# MEMORANDUM

FILE REF ACS Hillingdon International School, 108 Vine Lane, Hillingdon UB10 0BE

## RESPONSE TO LB HILLINGDON CONSULTEES

Please see our responses to the queries raised in the email from Richard Phillips (Hillingdon Council, Principal Planning Officer) dated 11<sup>th</sup> September 2023.

DRAWING TITLE
Landscape - Proposed General
Arrangement

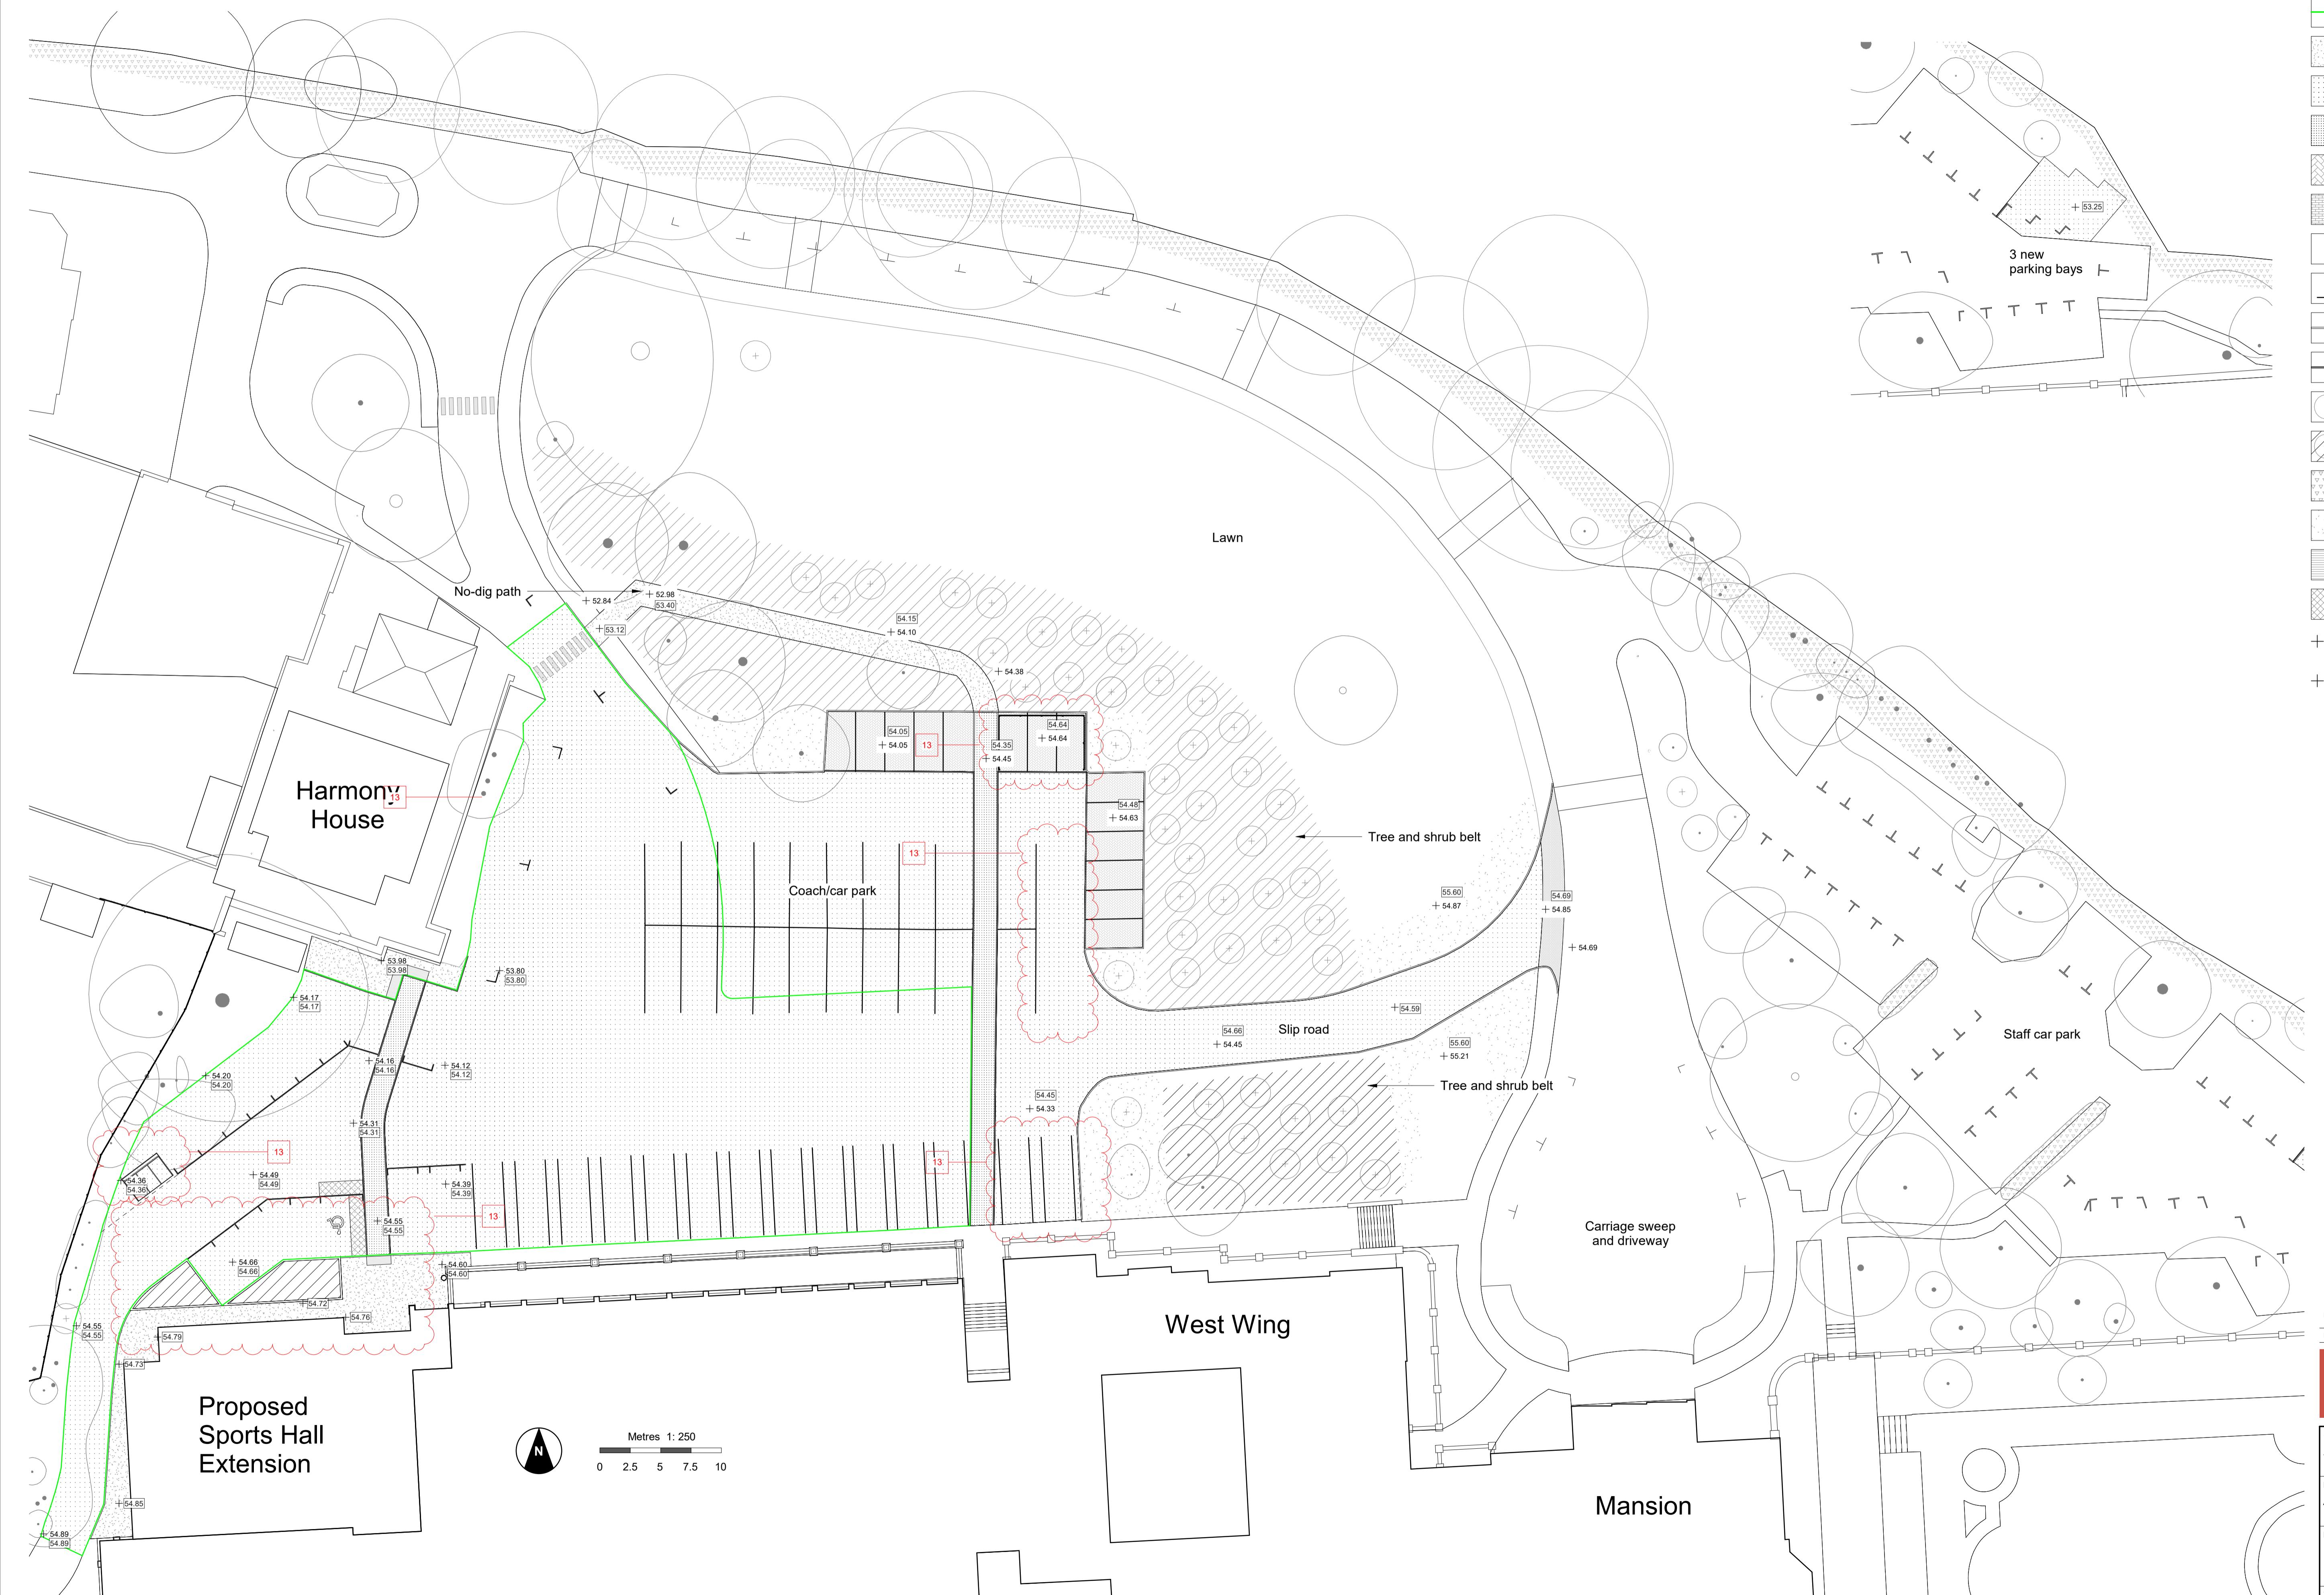
2	It should be ensured that there are no steep inclines, door lips or flights of stairs between the location of the external bin store and the collection point	This is confirmed by the architects and is reflected in IID's Hard Landscape Drawing and Nicola Maher's approved landscaping detail drawing.	1685-ID-PL-XX-DR-A-1062-P02 – Landscape – Proposals Hard Materials – This has been revised to show correct proposed level in refuse area
	3	The gradient of any path that the bulk bins must be moved on should be no more than 1:20, with a width of at least 2 metres without obstruction. The surface should be smooth	This is confirmed by the architects and is reflected in IID's Hard Landscape Drawing and Nicola Maher's approved landscaping detail drawing.	1685-ID-PL-XX-DR-A-1052-P02 – Landscape – Proposals Hard Materials – This has been revised to show correct proposed level in refuse area
	4	Roads providing access to the building should have foundations and a hard-wearing surface capable of withstanding a fully laden refuse vehicle of 32 tonnes Gross Vehicle Weight.	Confirmed – route is used currently used by a refuse collection vehicle and the school has no issues. There are no proposals to substantially amend the existing road.	0028-302 RevA Parking Bay Demarcation Coach / Car Park  N/A
